**From:** [REDACTED]  
**To:** [Aquind Interconnector; enquiries@BEIS.gov.uk](mailto:enquiries@BEIS.gov.uk)  
**Subject:** Aquind Interconnector - Secretary of State Consultation of 13 July 2021  
**Date:** 12 August 2021 18:36:03  
**Attachments:** [Let to BEIS 120821.pdf](#)

**Aquind Interconnector - Secretary of State Consultation of 13 July 2021**

TITLE: **Application document reference 2.7
Indicative Converter Station Area Layout Plans
Option B(i)
Sheet 2 of 3**

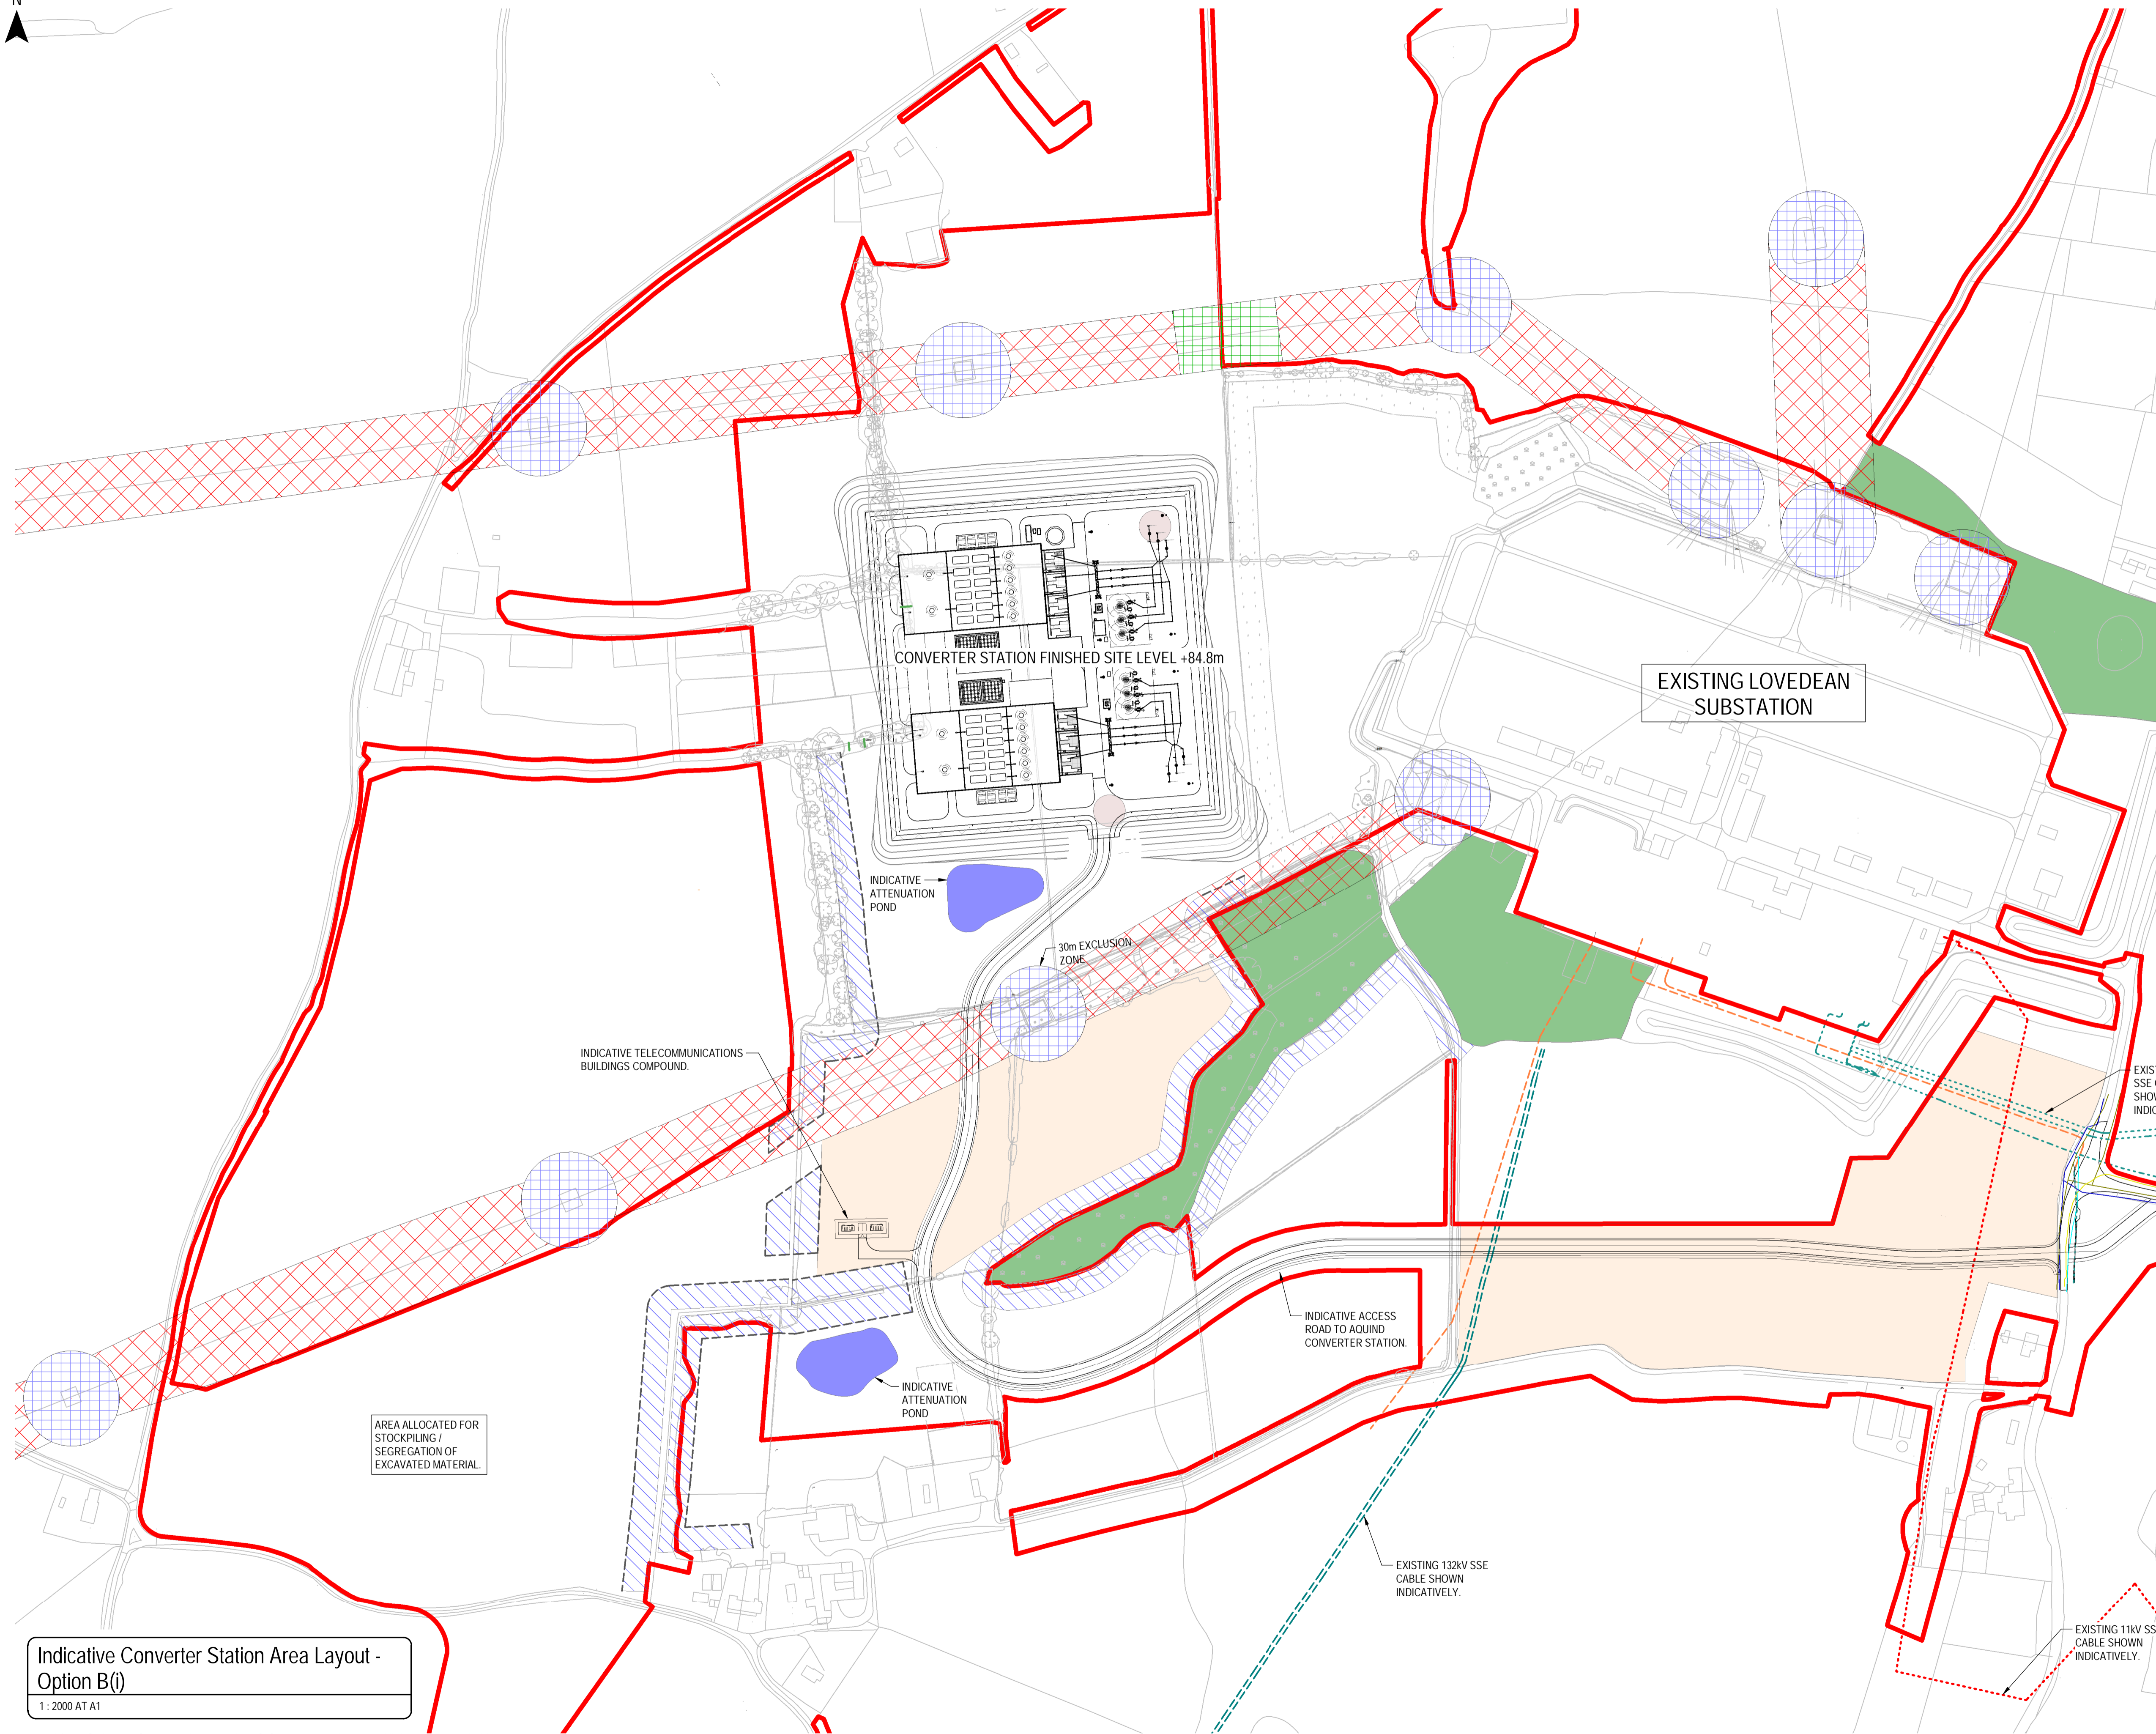
You will be aware that several objections were raised to the proposed siting of the converter station at Lovedean should the project go ahead. Aquind have indicated a preference for Option B(i) which requires the removal of a scientifically significant hedgerow but also put forward a secondary siting option (B(ii)) which moved it eastwards by some 35m. However, this latter option requires an agreement with the National Grid which, I believe, has still not been obtained. Option B(ii) would not affect the mature existing hedgerow screening which, if it were to be removed, would take several decades before any replacement planting reached similar effectiveness and maturing.

To prevent this happening, I respectfully request that Option B(i) be removed from the Aquind application and, in the event that negotiations with the National Grid are not concluded to allow the Converter Station to be sited at Option B(ii), that Aquind use the powers of compulsory purchase to obtain the necessary 35m of land from the National Grid to enable the siting of the Converter Station away from the existing mature hedgerow.
